Hydro Therapy Pool House Elevations As Proposed

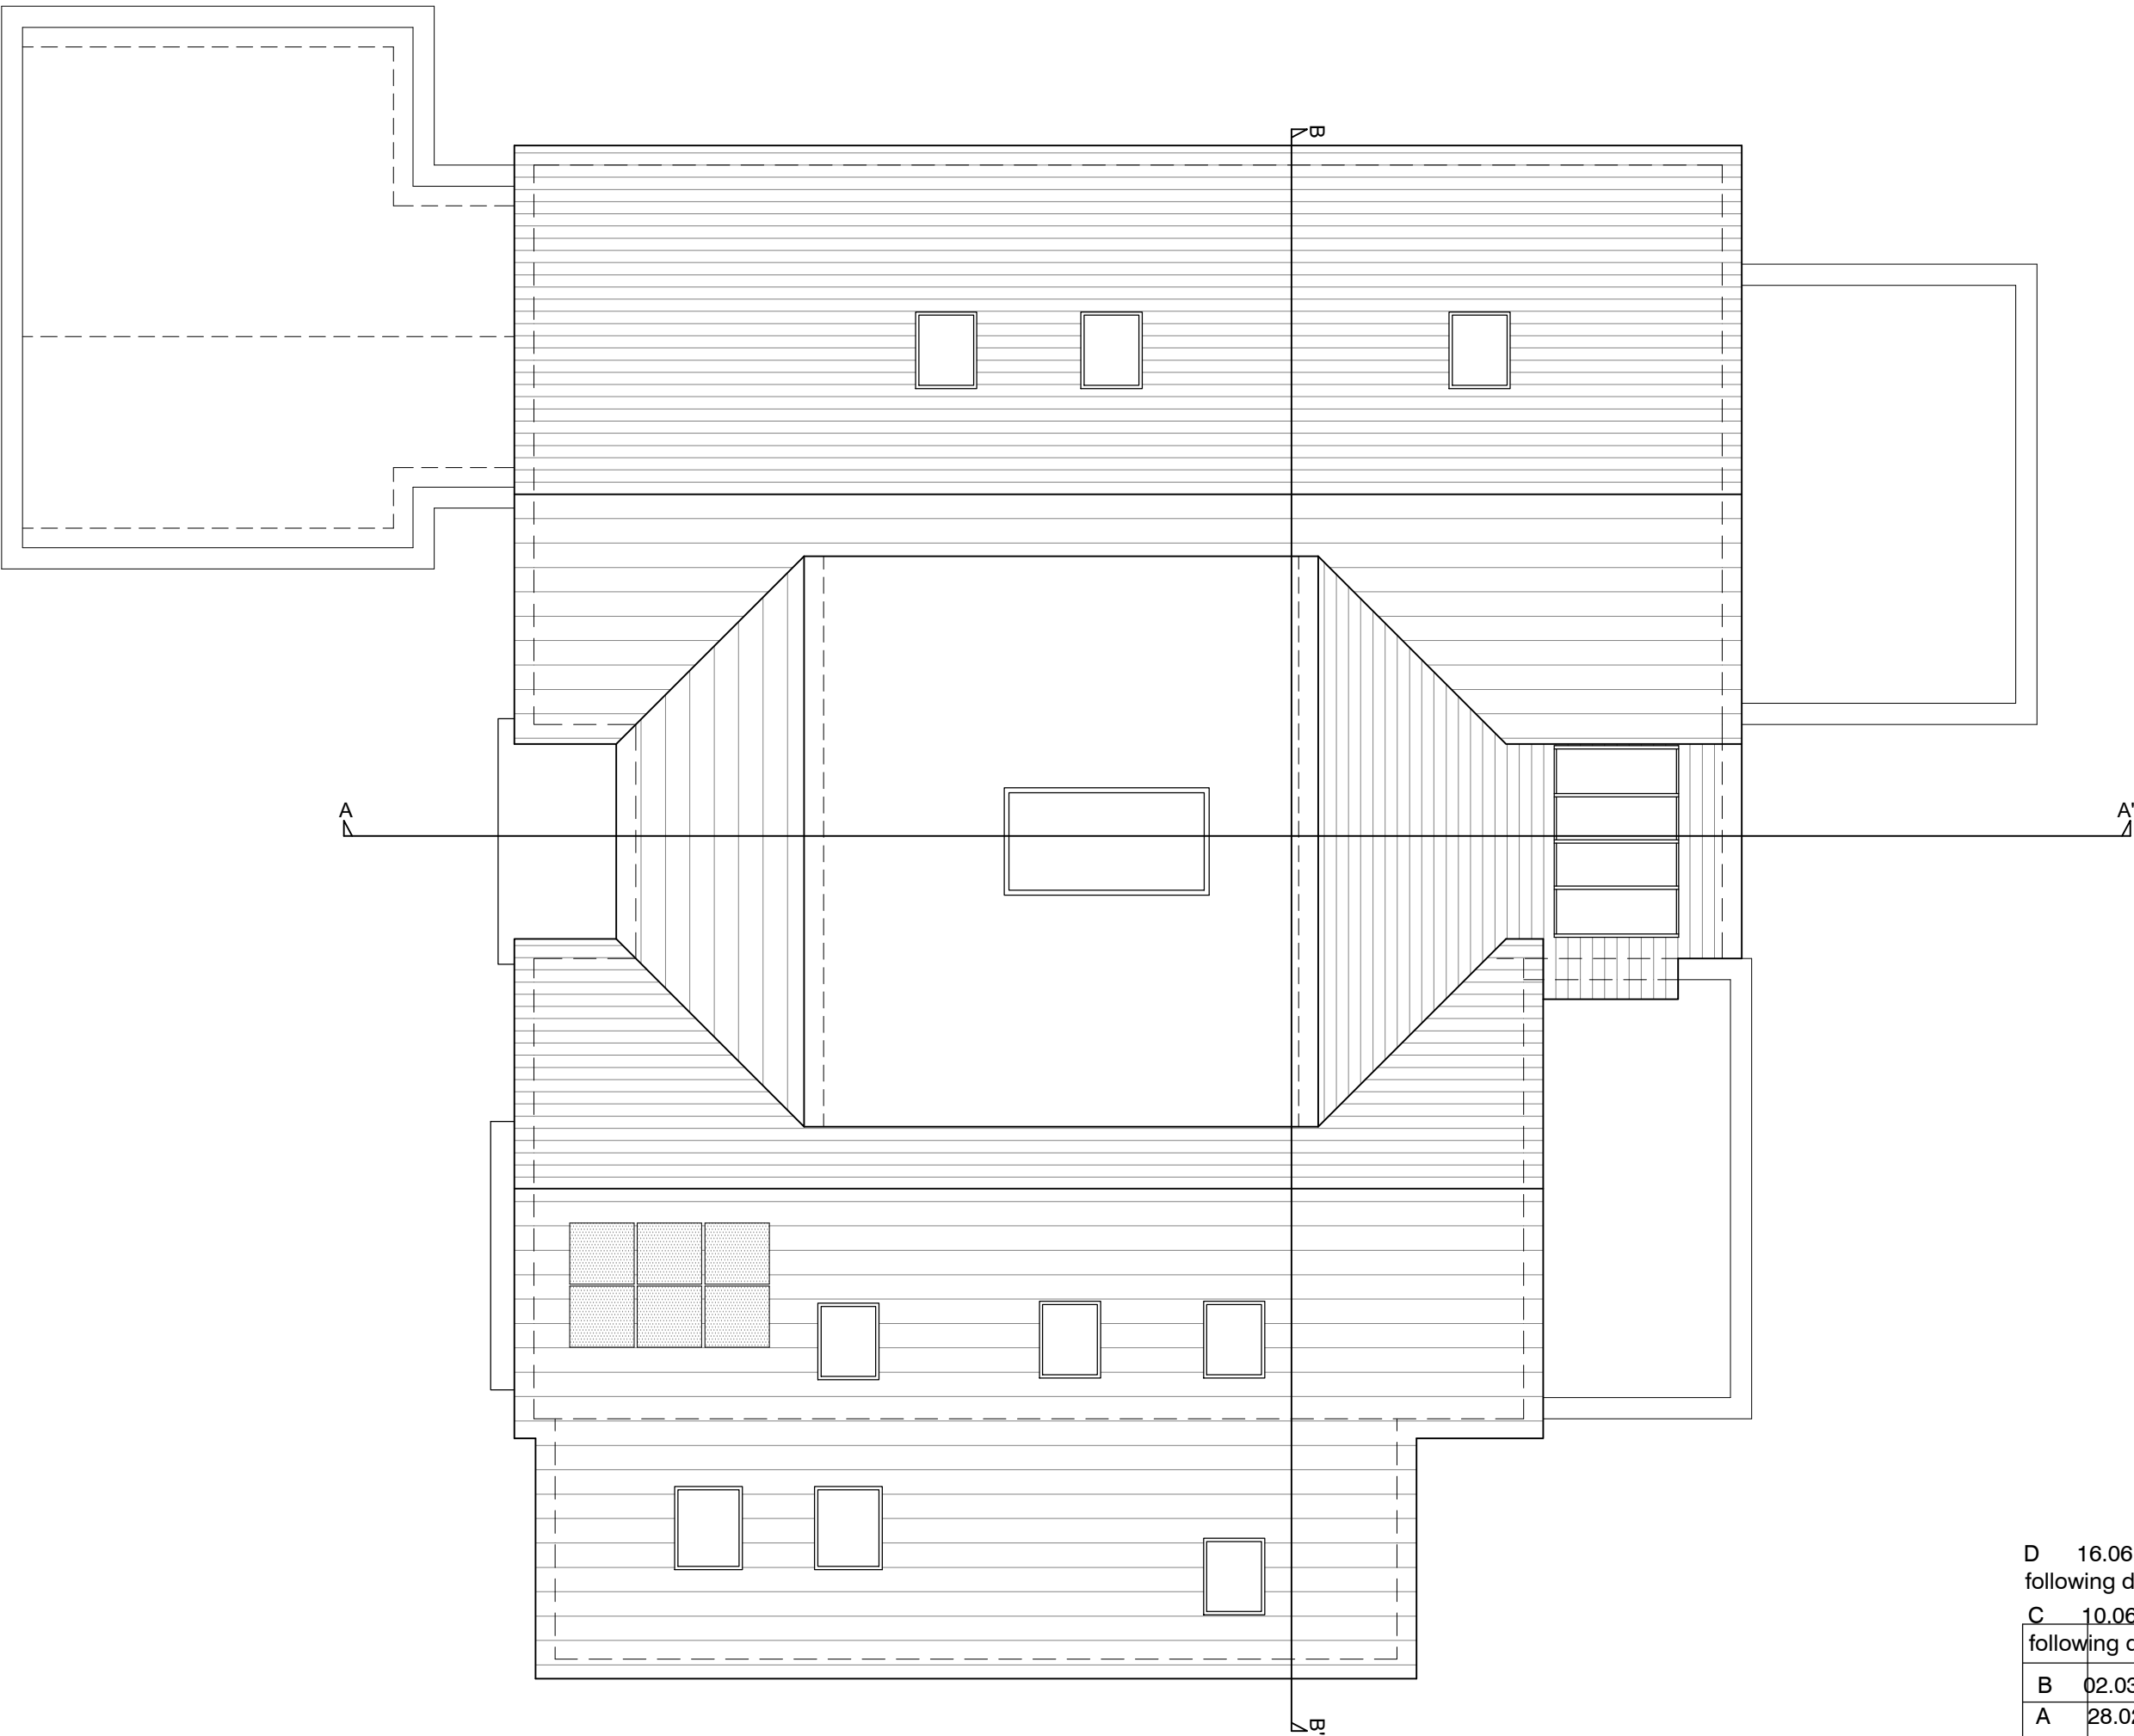
We have received an email from the neighbour at no.2 Grange Park questioning the change from flat to pitched roof for the pool house, and suggest significant impact from such a high ridge height. I had wondered this myself as it is a very high ridge height at 6m due to the equipment I think?

I have checked this with my Manager and they have said 'Given outbuilding is due west of one to rear think flat roof version has less overshadowing/overbearing impact.'

As such, sorry to be a pain, but can you send me please the amended physio pool drawing sheet with the flat roof instead? I'll then swop that back in.
